CITY OF ALBUQUERQUE

Re: Bobs Painting
8633 Paseo Alameda NE, 87113
30-Day Temporary Certificate of Occupancy
Transportation Development Final Inspection
Engineer's/Architect's Stamp dated 3-6-19 (C16D006U)
Certification dated 4-12-19

**TRAFFIC CIRCULATION PLAN**

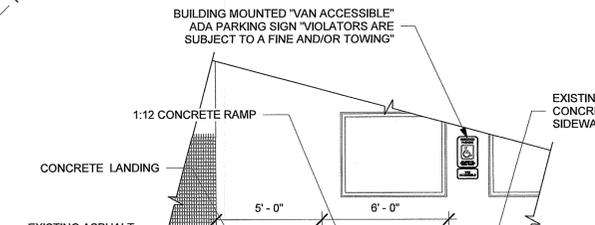
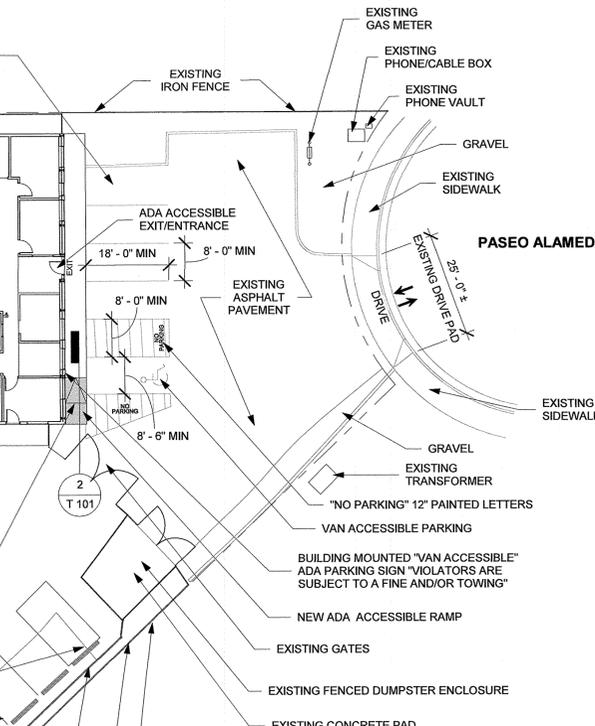
1. Please anchor bicycle rack.
(Bicycle racks shall be sturdy and anchored to a concrete pad. Chapter 23,
Section 3.11)
2. Please add ADA Accessible Ramp to west exit door per the approved TCL
plan.
3. Please send photos of correction for release of final CO.
